Arun District Council
Arun Civic Centre
Maltravers Road
Littlehampton
West Sussex BN17 5LF
Planning & Building Control General Enquiries
Tel: (01903) 737756 Fax: (01903) 730442
Dx: 57406 Littlehampton
Minicom: 01903 732765
e-mail: planning@arun.gov.uk
website: www.arun.gov.uk/planning

Application No: CM/48/21/RES
Site Address: Land to the West of Church Lane South of Horsemere Green Lane Climping
Description of works: Approval of reserved matters following the grant of CM/1/17/OUT for the erection of 300 No dwellings & a building within use class E, together with public open space, LAPs, LEAP & ancillary works, including car parking & drainage arrangements, with access off Church Lane & Horsemere Green Lane. This application may affect the setting of listed buildings & is in CIL Zone 4 (HSP2) & is not CIL Liable.

Thank you for your internet representation made on 5th October 2021 which has been recorded as an objection with the comments as follows:

Revision N
Project Land at Climping Littlehampton
Title Site Plan
Dwg# 20.050.02
Status Planning

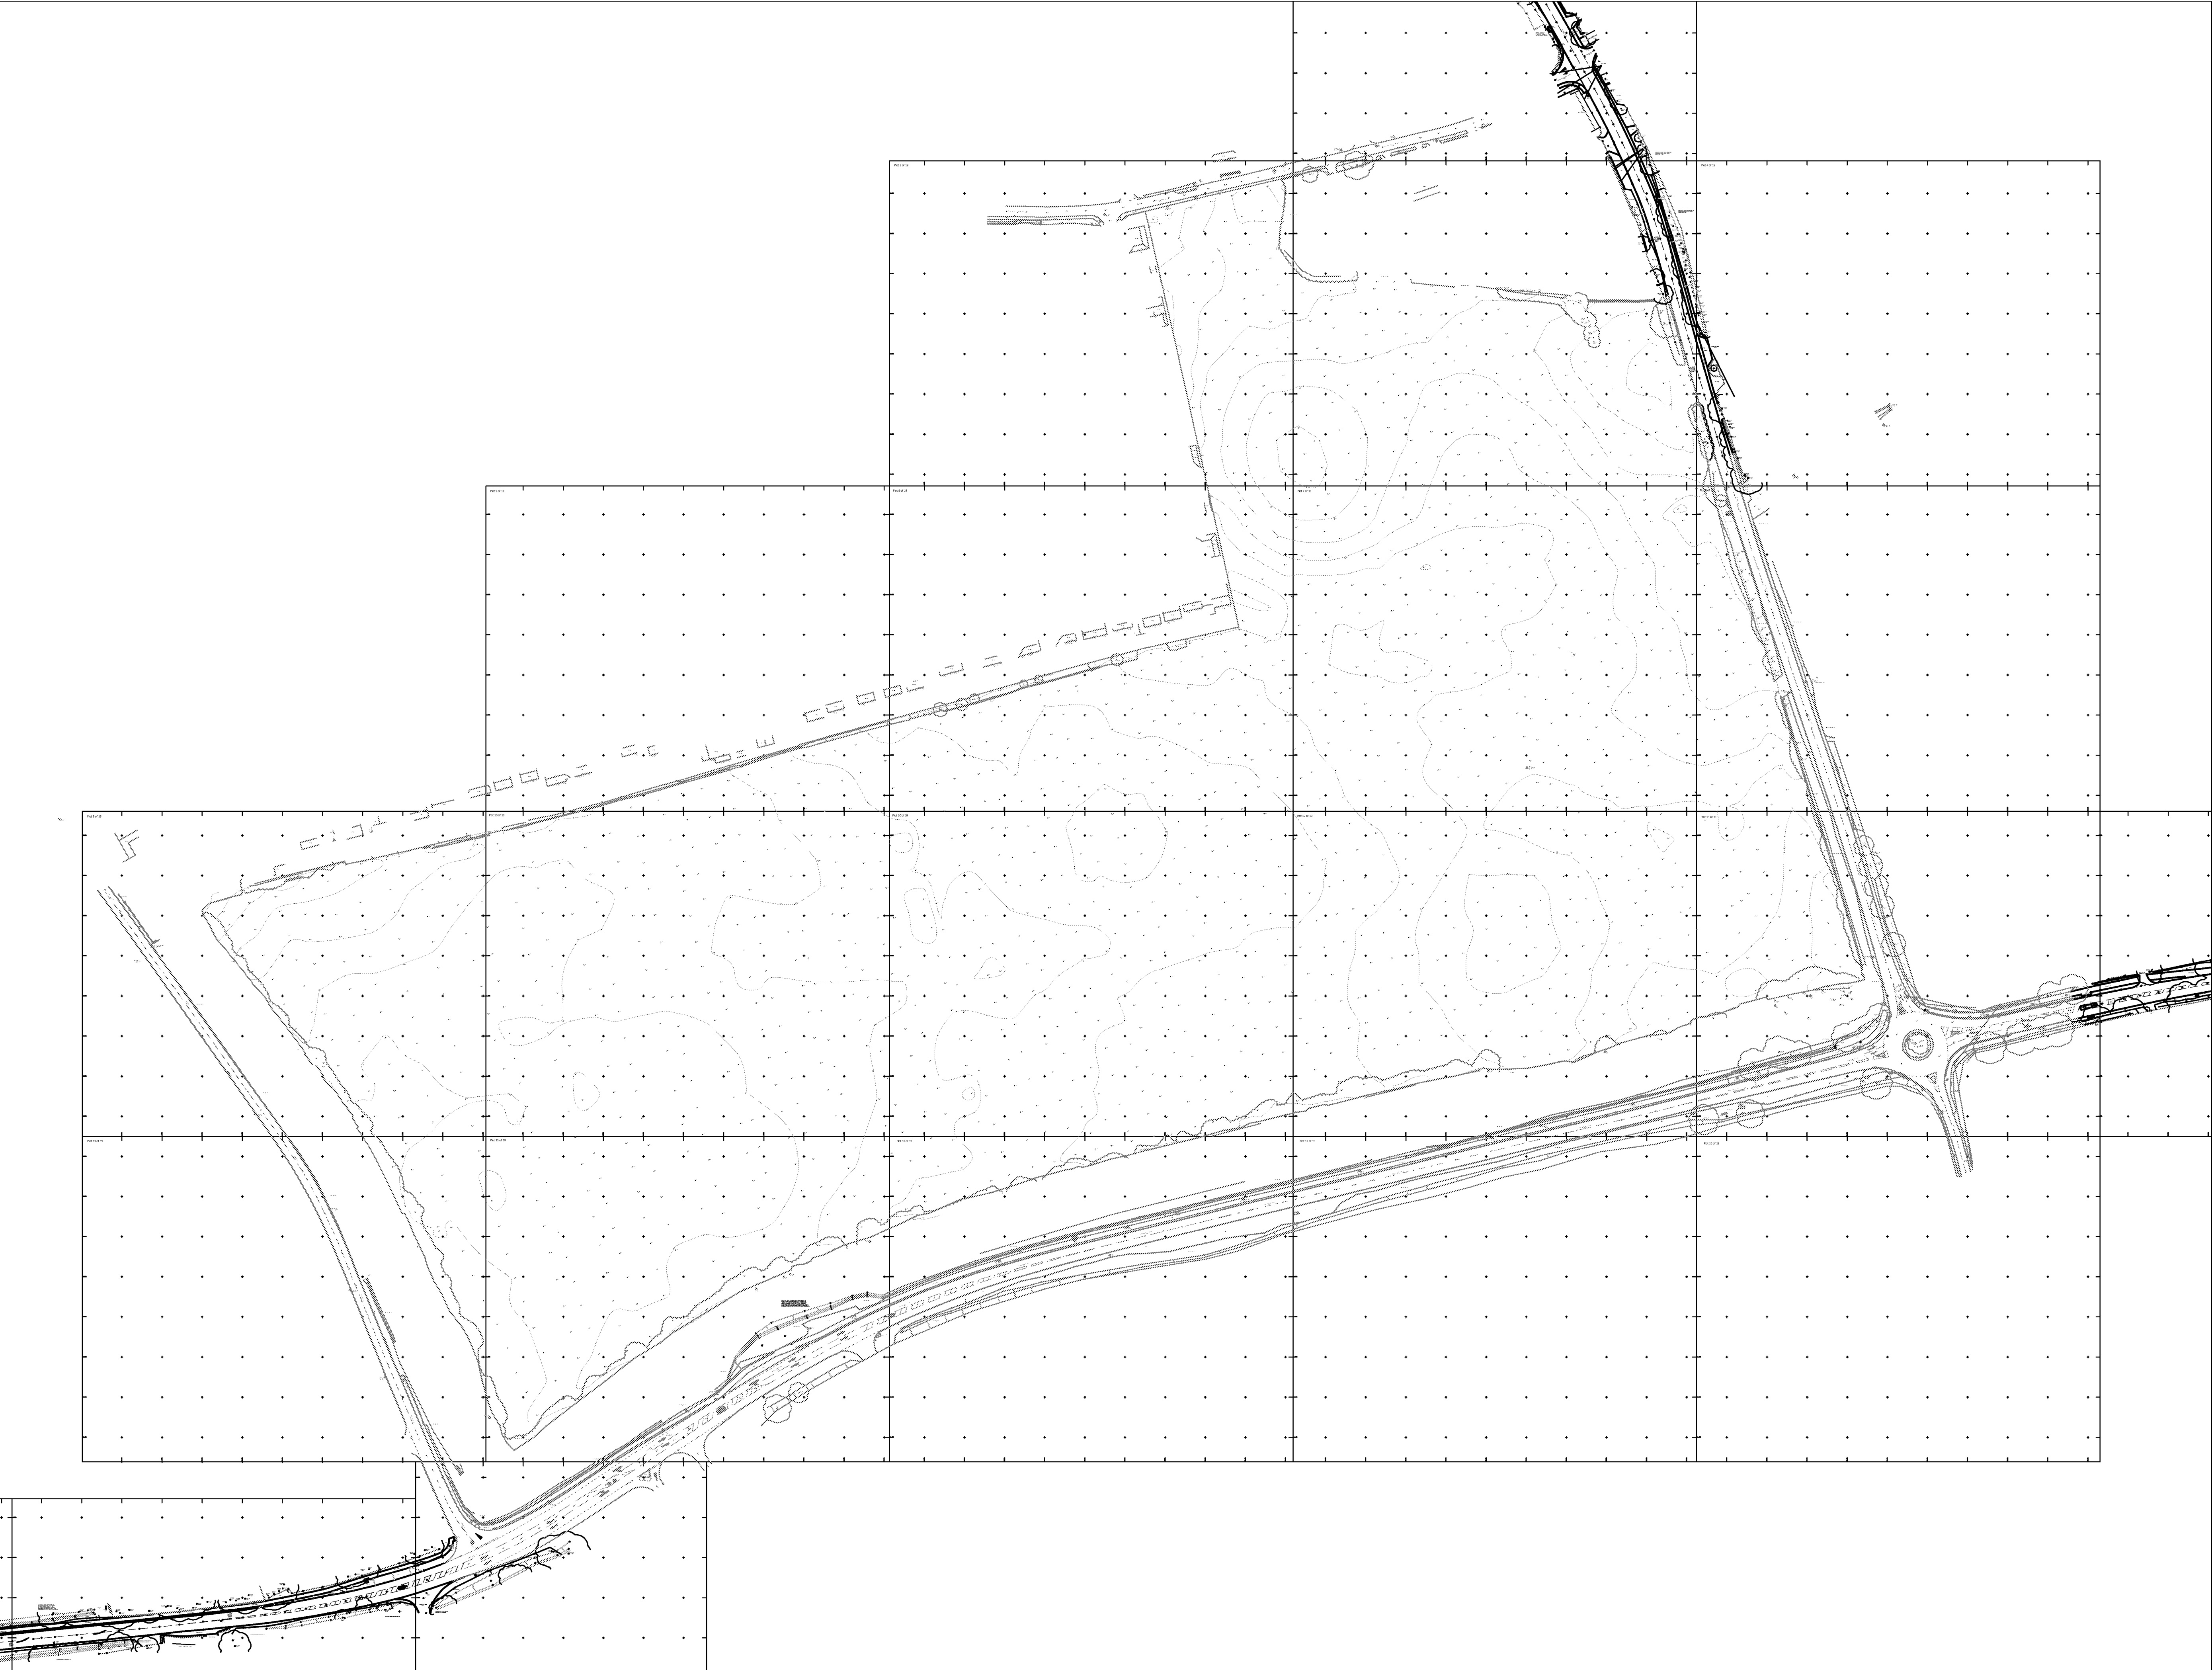
1 - I have looked at the layout plans and am concerned that there is a open ditch running the full length of the road backing onto the existing properties. Not only we we have the additional noise from cars, light from the street lights but also have the issue of the ditch attracting vermin and also stagnant water. Who will maintain the ditch so it does not become a rubbish tip.

2- I also note that unfortunately backing onto my property there will also be 6 car parking spaces supposedly for visitors, It is unlikely that they will be used for visitors but if they are then we will also have additional noise from all the visitor. Why bunch all the car park spaces together, could they not be spaced along the length of the road? or placed on the western side of the site where the green space is.

4 - The developer is providing a green space as a buffer along the length of Crophorn and the properties in at the eastern end of Horsemere Green Lane and Church Road, why have we not got the same for all the properties on the northern boundary? The whole development could be extended westward on the southern boundary allowing a green buffer on the Northern side. The buffer would also act as an environmental corridor, allowing movement of animals from Yapton Road to Church Lane.
